B20/0015

RE: Building Permit vis-à-vis Lot 18, Block 16, Tract 1, Unit 3, North Albuquerque Acres

Carlos A. Montoya
City Floodplain Administrator

PANEL 133 OF 825

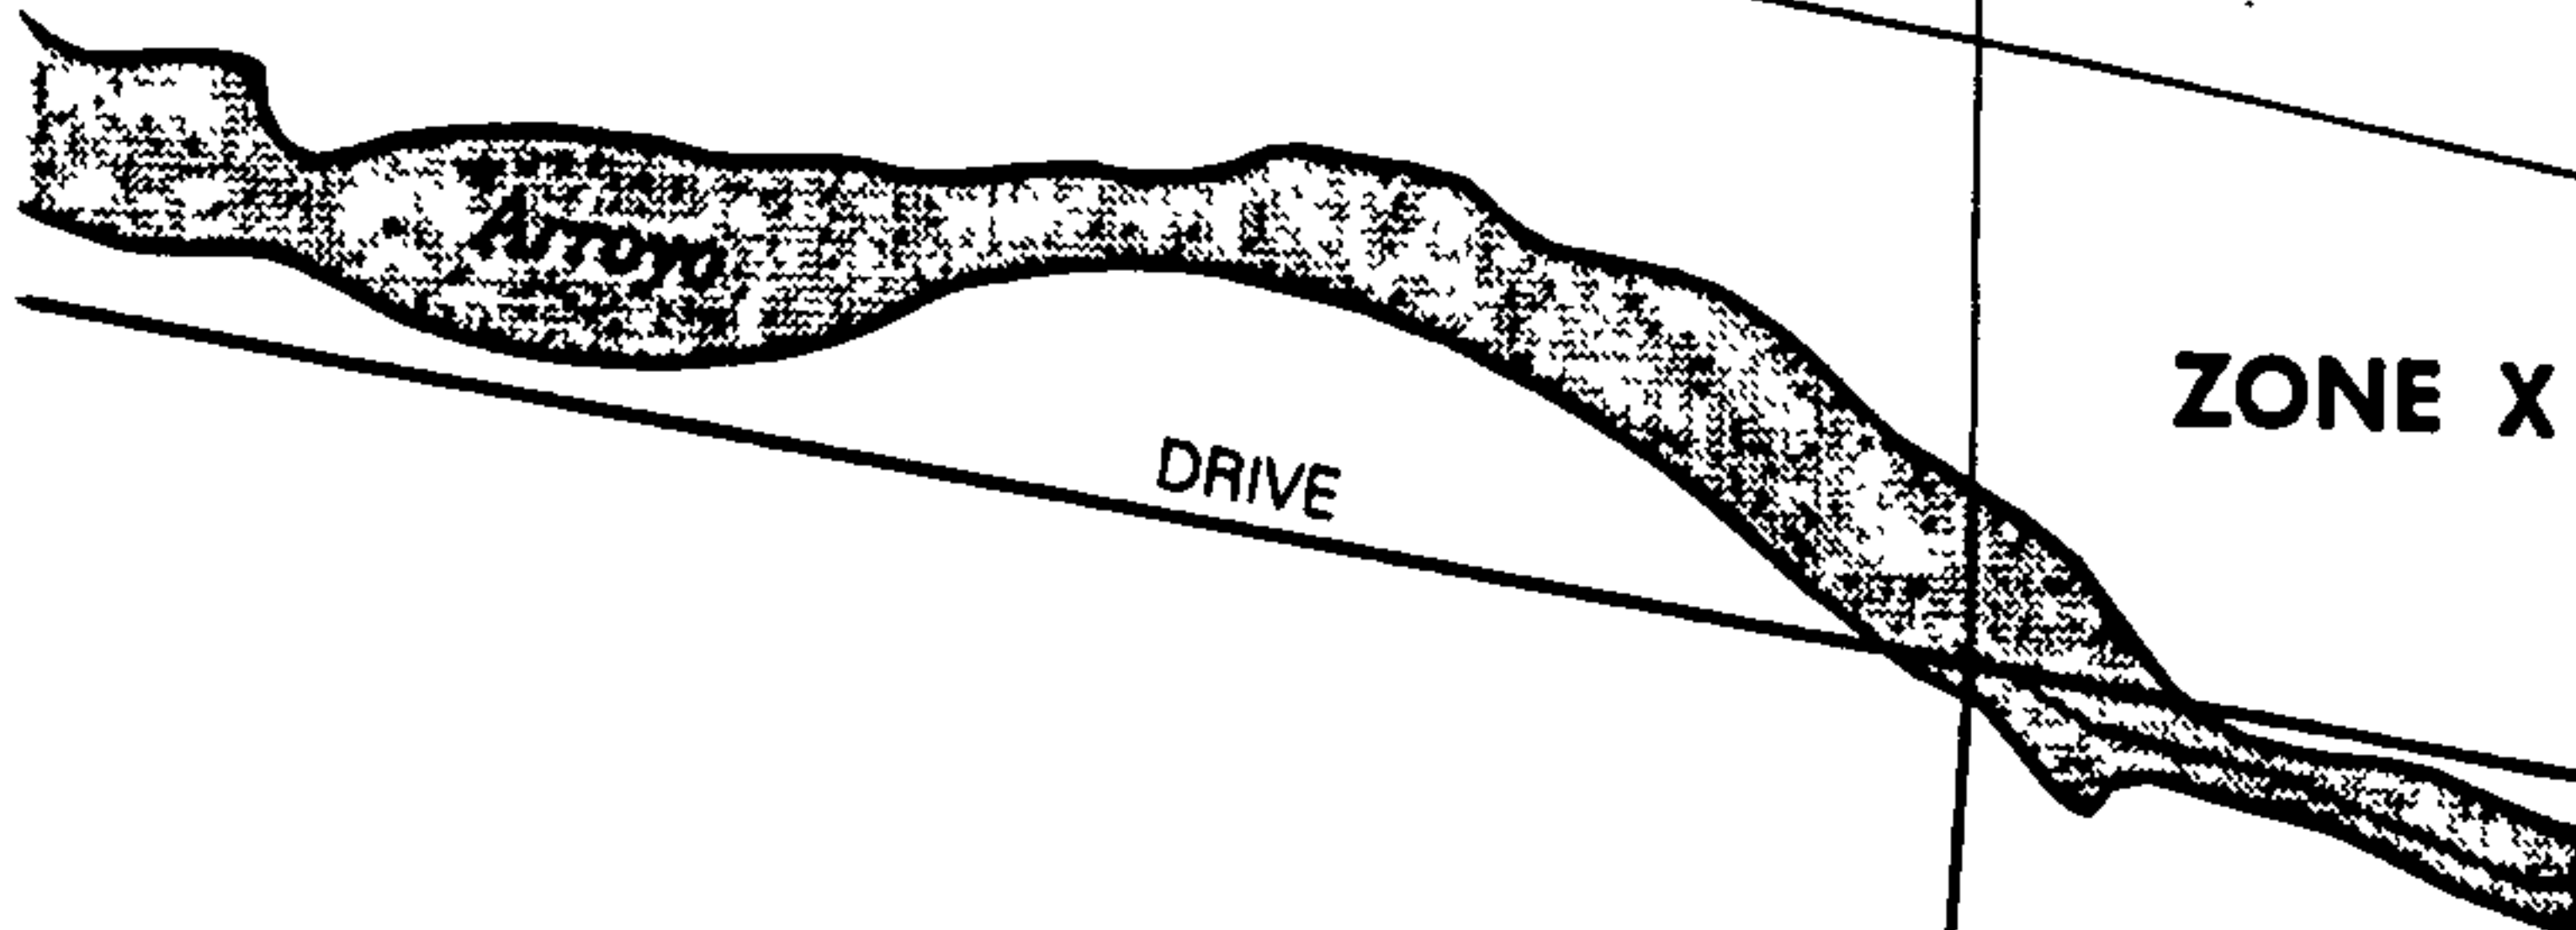
1. Zone Atlas Page B-20-Z showing lot 18. The shaded area is outside the city limits.
2. An aerial photo from the City's AGIS, which was flown in 1999. The aerial photo shows the lot 18, outline of the 100-year floodplain (blue dotted), and surrounding roads.
3. Contour drawing for lot 18 showing the 100-year floodplain, and the 100-year storm runoff of 673 cfs adjacent to lot 18 (cfs is short for cubic feet per second which is the standard for measuring runoff of water).
4. A portion of the City's Drainage Ordinance (Section 14-5-2-7-(F))
5. A portion of the Flood Insurance Rate Map (Panel 133) showing the 100-year floodplains in the vicinity of your lot.

The 100-year floodplain is located adjacent to the south side of your lot on Glendale Avenue. The 100-year floodplain is that area impacted by the 100-year storm. The 100-year storm is precipitation within a six-hour period and resulting runoff that has a 1% chance of being equaled or exceeded in any given year.

The information above indicates that during the 100-year storm, the runoff within the floodplain adjacent to your lot is 673 cfs with a depth of 1 and 2 feet. Glendale Avenue, the road by which you access the property is clearly within the floodplain. Access to your property from Glendale Avenue during the 100-year storm would be extremely dangerous. The velocity and depth of the runoff could stall vehicles and carry them downstream. To mitigate the danger and protect against loss of life and property the City's Drainage Ordinance requires that an all-weather access road be provided to the property during the 100-year storm.

A building permit cannot be issued for this property unless a 100-year all weather access is constructed, or alternative ingress and egress is provided to the lot that does not cross the 100-year floodplain. Of course there would have to be legal access for the alternative access.
If you have any questions please call me at 924-3982.
